CANAL PLAZA HOTEL

LEVEL III SITE PLAN PRELIMINARY PLAN FINAL PLANNING BOARD MEETING AND PUBLIC HEARING

October 2, 2012

Union and Fore Street Hotel, 433 Fore Street, Portland Maine

EXHIBIT-05

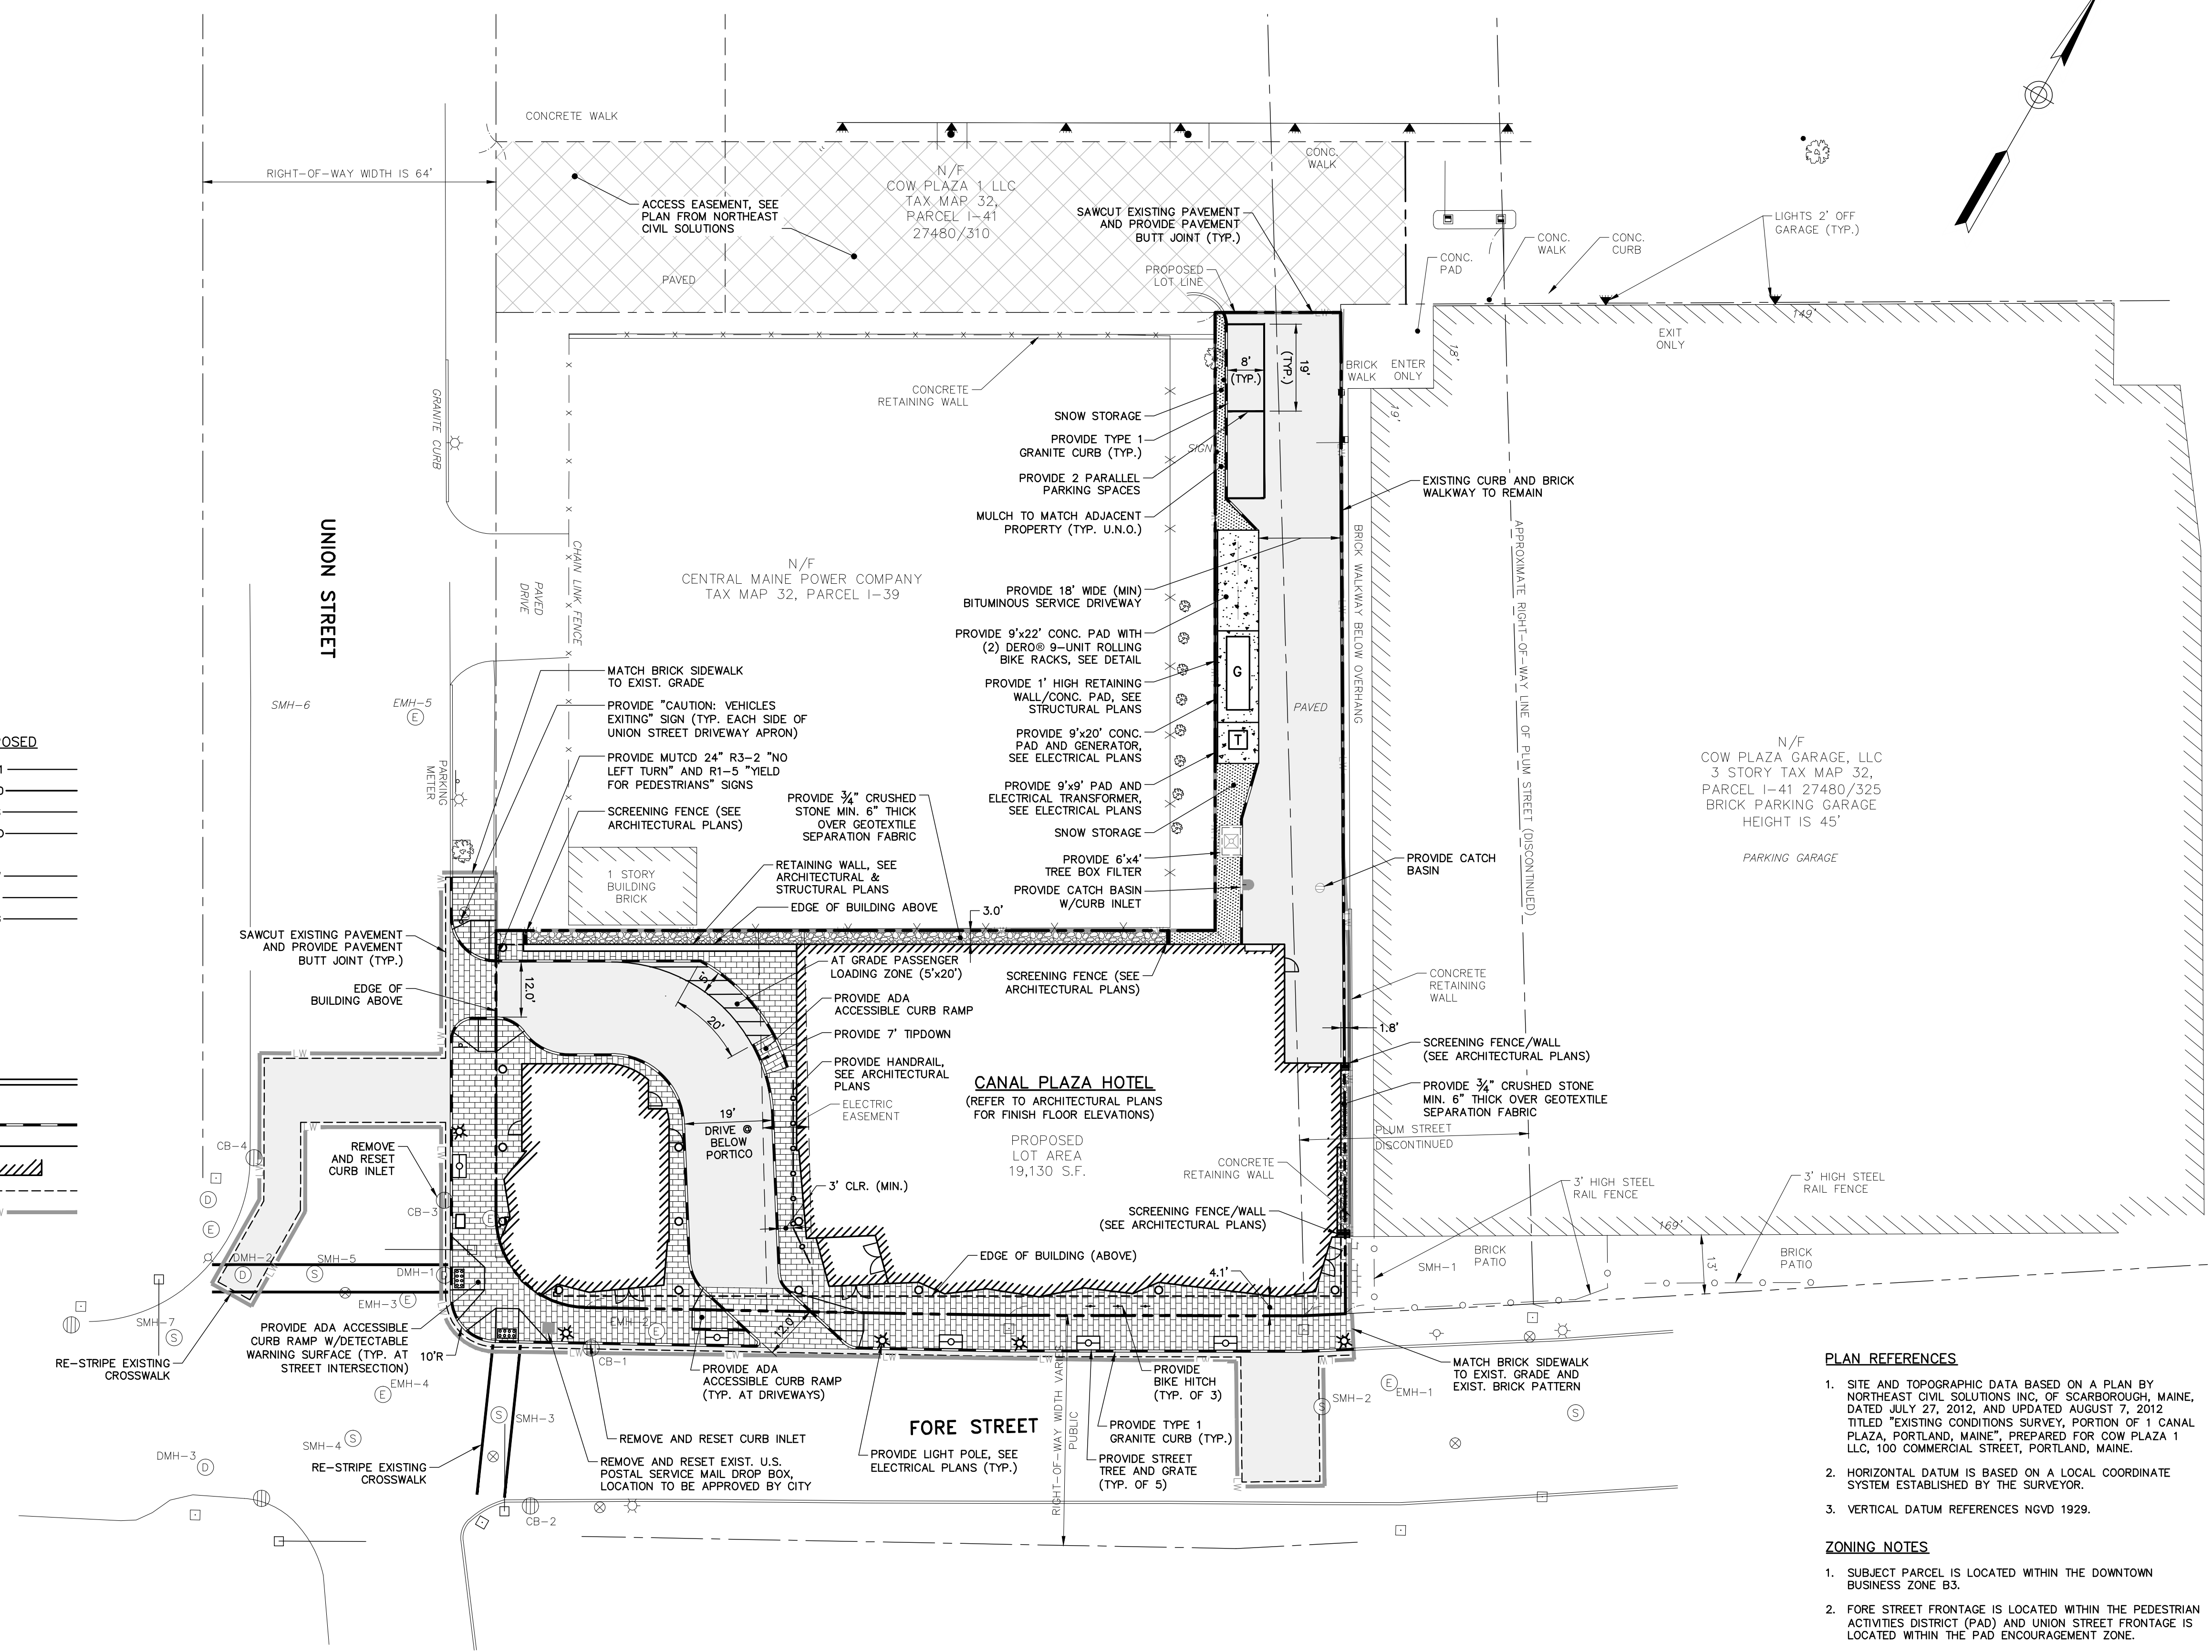
- A landscaping plan (the site plan shows no landscaping at the base of the building, but the 'preliminary landscaping sketches' from the LA do):

Please refer to attached updated Landscape Plan for additional information.
